From: Laura Gibbons
Sent: 16 May 2018 13:02
To: Planning.Responses
Subject: Planning Consultation on BE/56/18/DOC

Comments relating to Condition 5- Surface water drainage

This drawing is the copyright of Robert Clark Associates Limited It may not be copied or reproduced without their written authority	
Scale 1:20	At original A3
Drawing Number 1787/D5.1	Revision -

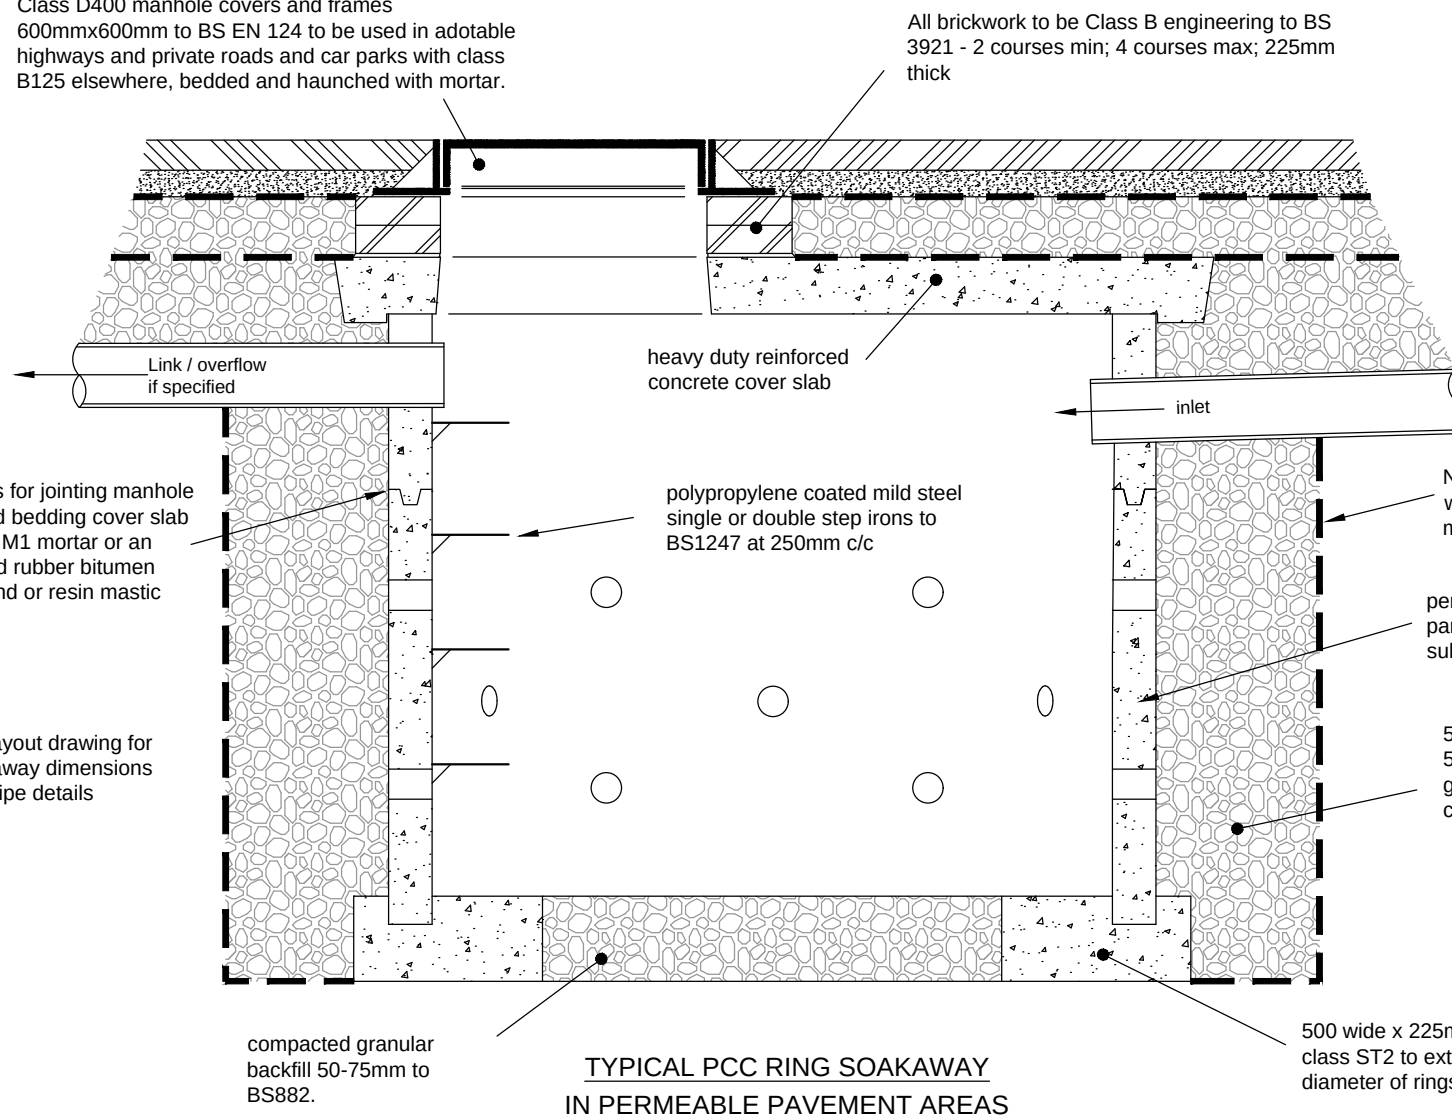
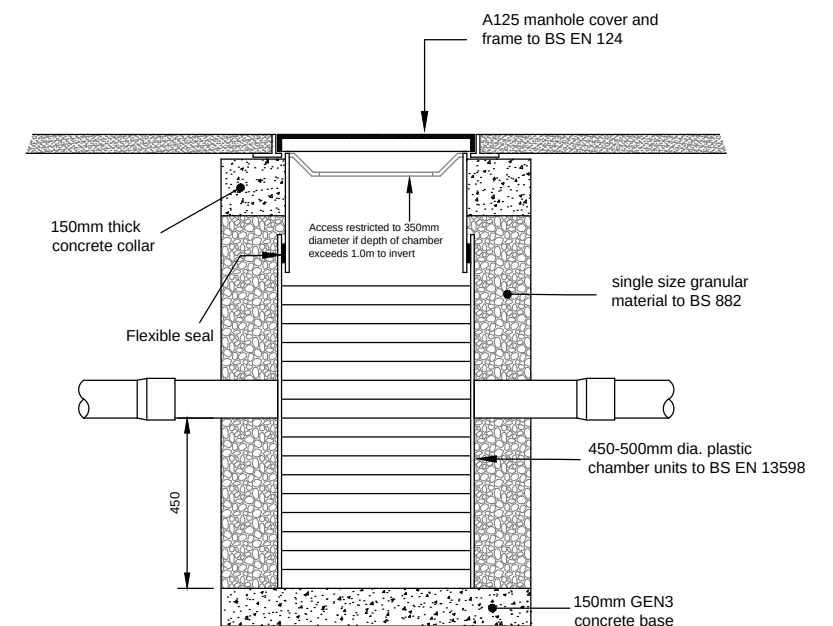
Further to your response attached, could you reconsider, as the 21mm of surcharge can easily be contained within the 100mm of granular surround to the crates and within upstream pipework/ manholes etc. We are showing no flooding on a 1 in 100 year event + 40% cc and I would request that a little surcharging is acceptable.

As the surcharging is small, and as you say the 100mm granular surround should take this, I will accept the surcharging in this case.
